Case Officer: Caroline Ford

Applicant: A2 Dominion Group/P3Eco (Bicester) Ltd

Proposal: Partial Discharge of Conditions 31 & 72 of 10/01780/HYBRID – the area immediately to the north and south of the southern site access only

PROJECT NO. ALD654	DRAWING NUMBER: PL401	REVISION: P06
-----------------------	--------------------------	------------------

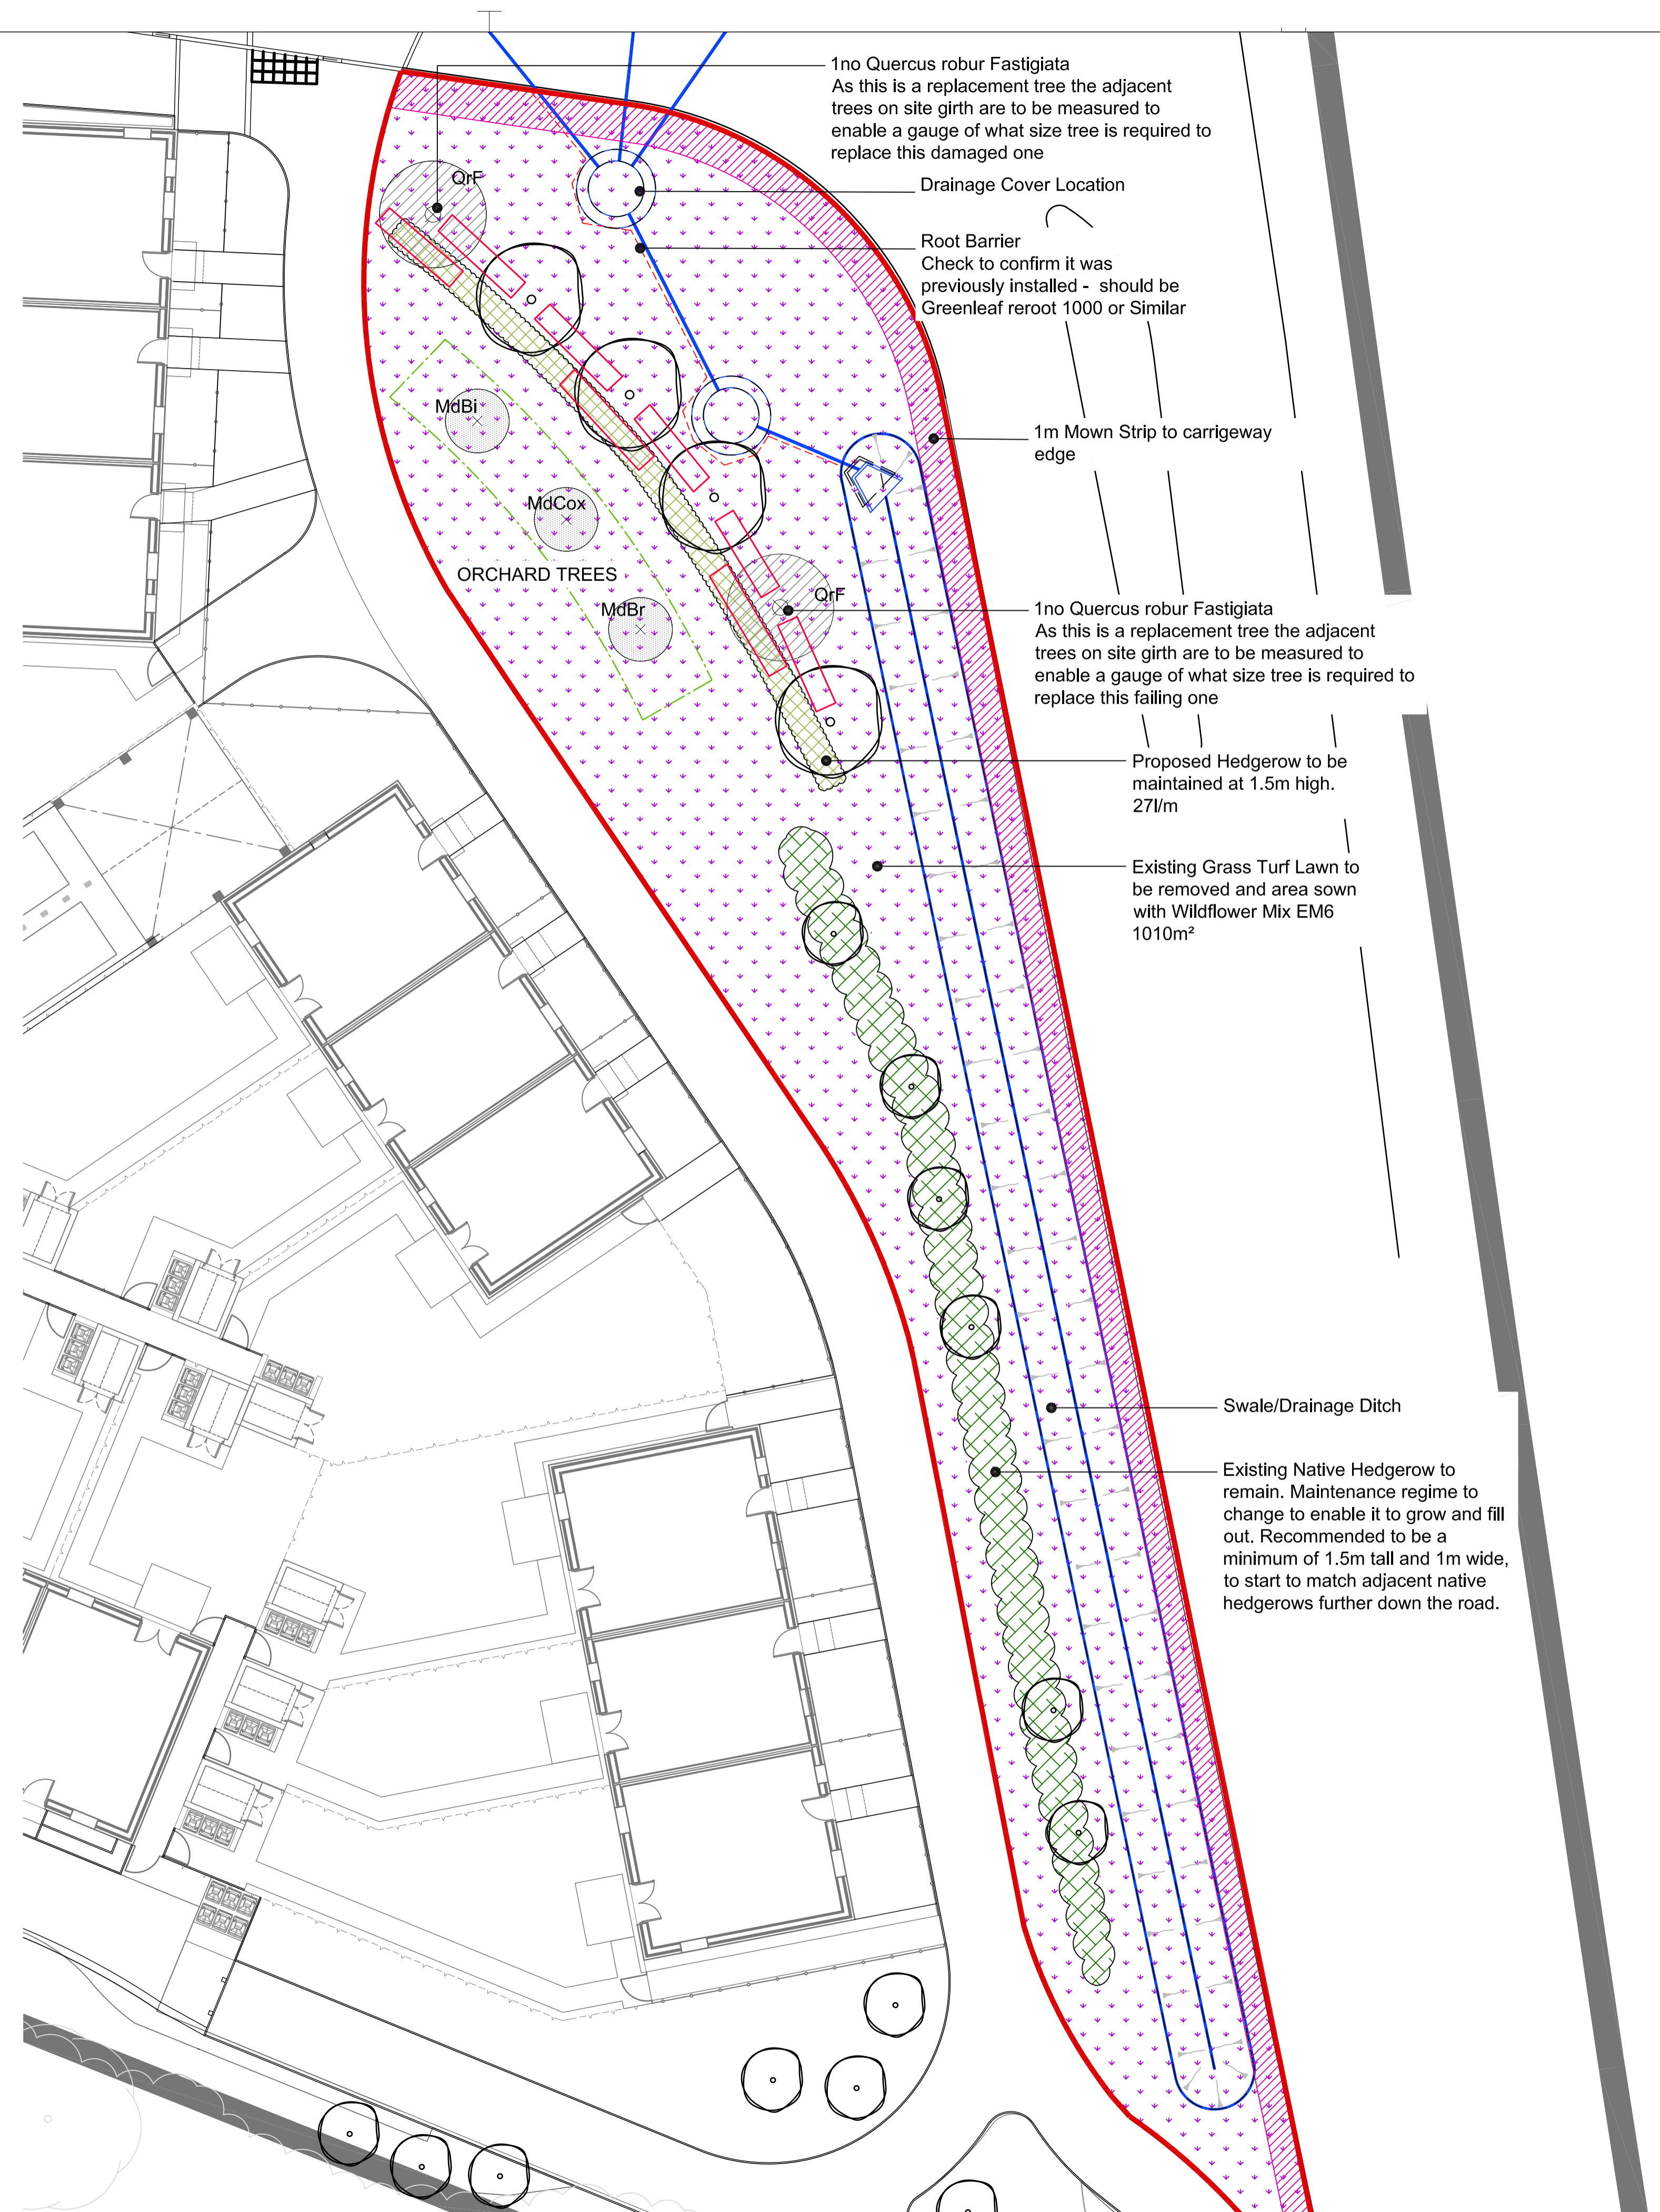
- 5.3 The landscaping scheme for approval is submitted pursuant to both conditions 31 and 72. Initially, the intention was that hedgerows would be translocated to create a hedgerow entrance to the site at the southern entrance. However, parts of these translocated hedgerows have not survived and as such the proposal is in mitigation for the translocated hedgerow (condition 72) and a landscaping scheme for the site frontage (condition 31). The initial landscaping scheme was considered by the Landscape Team and various comments were made seeking amendments. These were not responded to, however now the applicant wishes to agree these details and has amended the scheme. A couple of iterations of the plans have been provided responding to comments made through this recent process and the Landscape and Arboricultural Teams have now confirmed that the landscaping scheme for this frontage is acceptable.

- 5.4 I have no reason to disagree with this assessment. To the Northern side of the site access, the proposal shows a native hedgerow mix incorporating trees to be maintained at 0.8m high with a mown amenity grass strip and two quercus robur fastigiata (oak) (which have been reduced from three in number to two given their proximity to the adjacent dwelling to be constructed) surrounded by a wildflower mix. To the Southern side of the site access, it is proposed to remove the existing laurel hedges and to provide in its place a carpinus betulus (hornbeam) hedge to be 1.5m tall to be close to an existing line of trees although two of which need to be replaced (also oaks which reflect those to the northern side of the entrance). As this area was also to include an orchard, three apple trees are to be planted within a trenched area to give them the best chance of survival. The existing grassland within this area would be removed and replaced with a wildflower mix. In my view, these proposals will provide for an acceptable landscaping scheme at the site frontage and which will be more native than ornamental therefore creating a more suitable frontage more in line with what was originally envisaged.

Condition 31: The landscaping scheme shown on drawing numbers PL401 Rev P06 (South Frontage Soft Landscape Scheme) and PL402 Rev P05 (North Frontage Soft Landscape Scheme) is considered to be an acceptable landscape scheme for the area to the north and south of the southern access only.

Condition 72: The landscaping scheme shown on drawing numbers PL401 Rev P06 (South Frontage Soft Landscape Scheme) and PL402 Rev P05 (North Frontage Soft Landscape Scheme) is considered to be an acceptable landscape scheme for the area to the north and south of the southern access only.
